**Florence Villa
Hangleton Lane
Ferring
West Sussex
BN12 6PP**

Your ref FG/134/13

The notice for this has just gone up - 20 Nov 13. I live 2 doors up the Lane from the site. I would wish to object to the application for the following reasons.

Client
PEUGEOT MOTOR COMPANY plc
Project
Yeomans
Littlehampton Road
Ferring
Worthing
BN12 6PB
Drawing
PROPOSED EXTERNAL LIGHT PLOT
Drawn by Date Scale
CY SEP 2013 1:200
Drawing No. Revision
1541/4

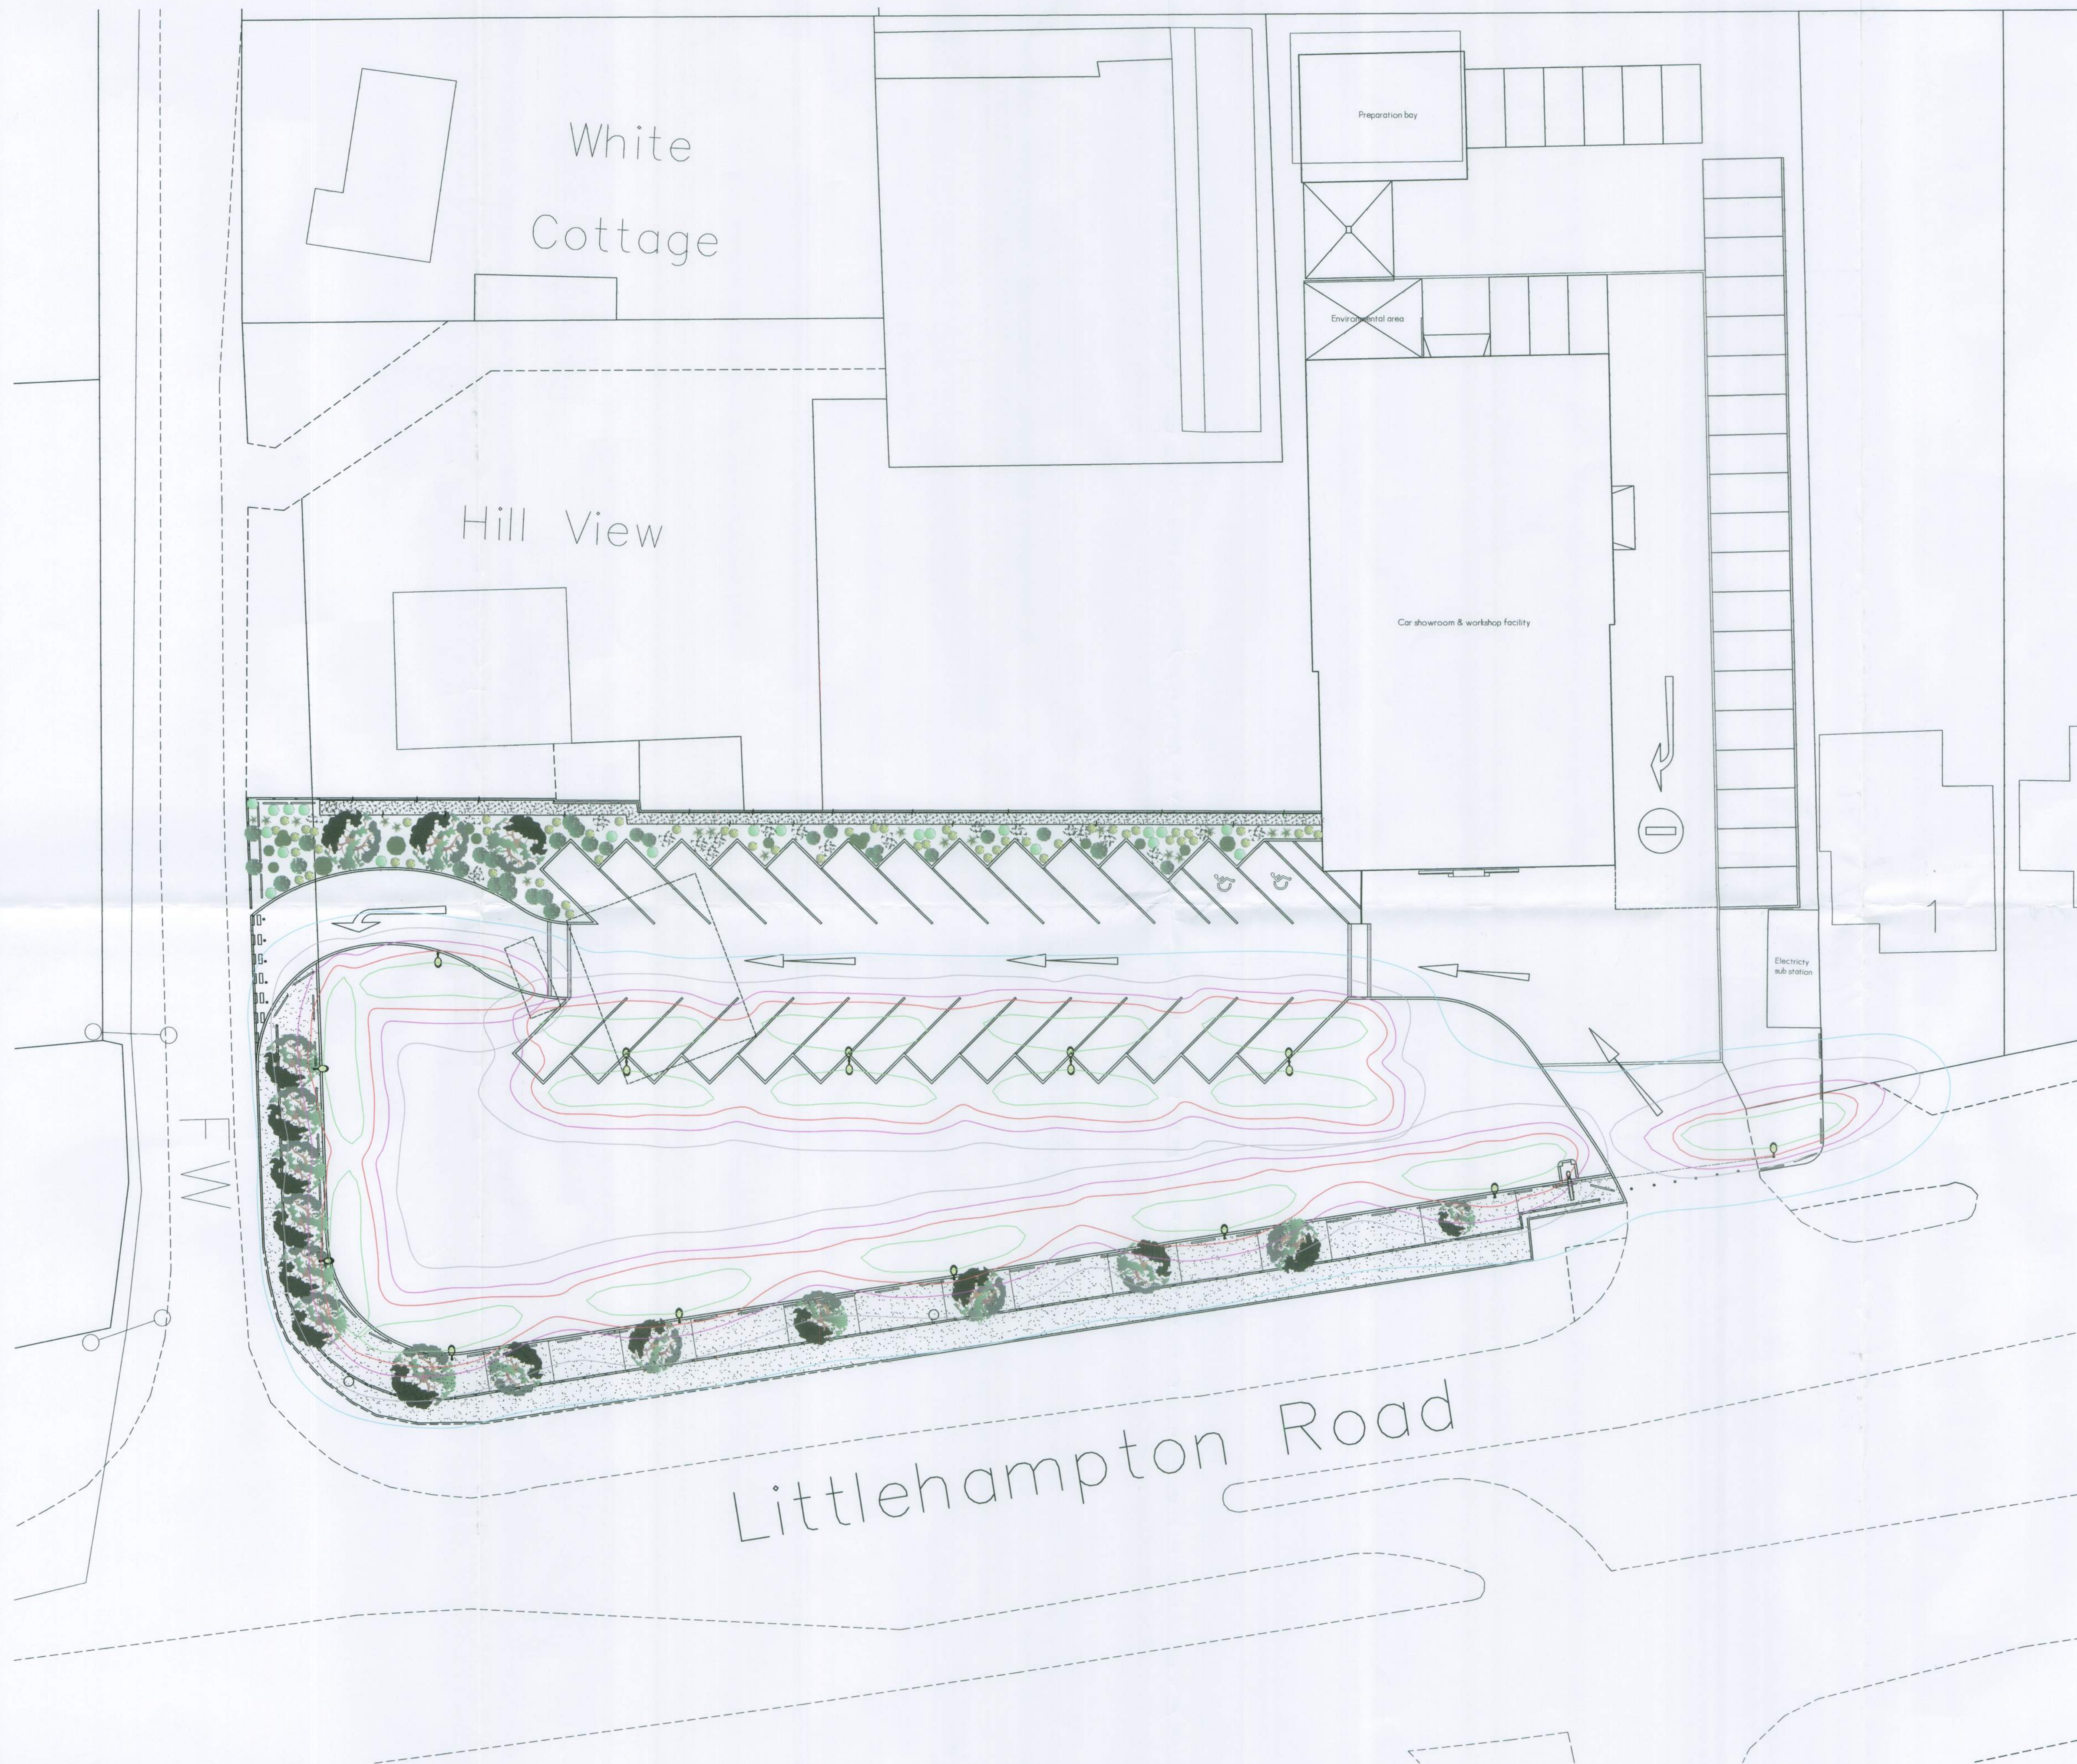
2. The plan will increase light and noise pollution; I note that it is said that the floodlights will only be used in working hours - what are the hours for "working"? - but in fact the very bright and intrusive floodlight in present use is on all night!
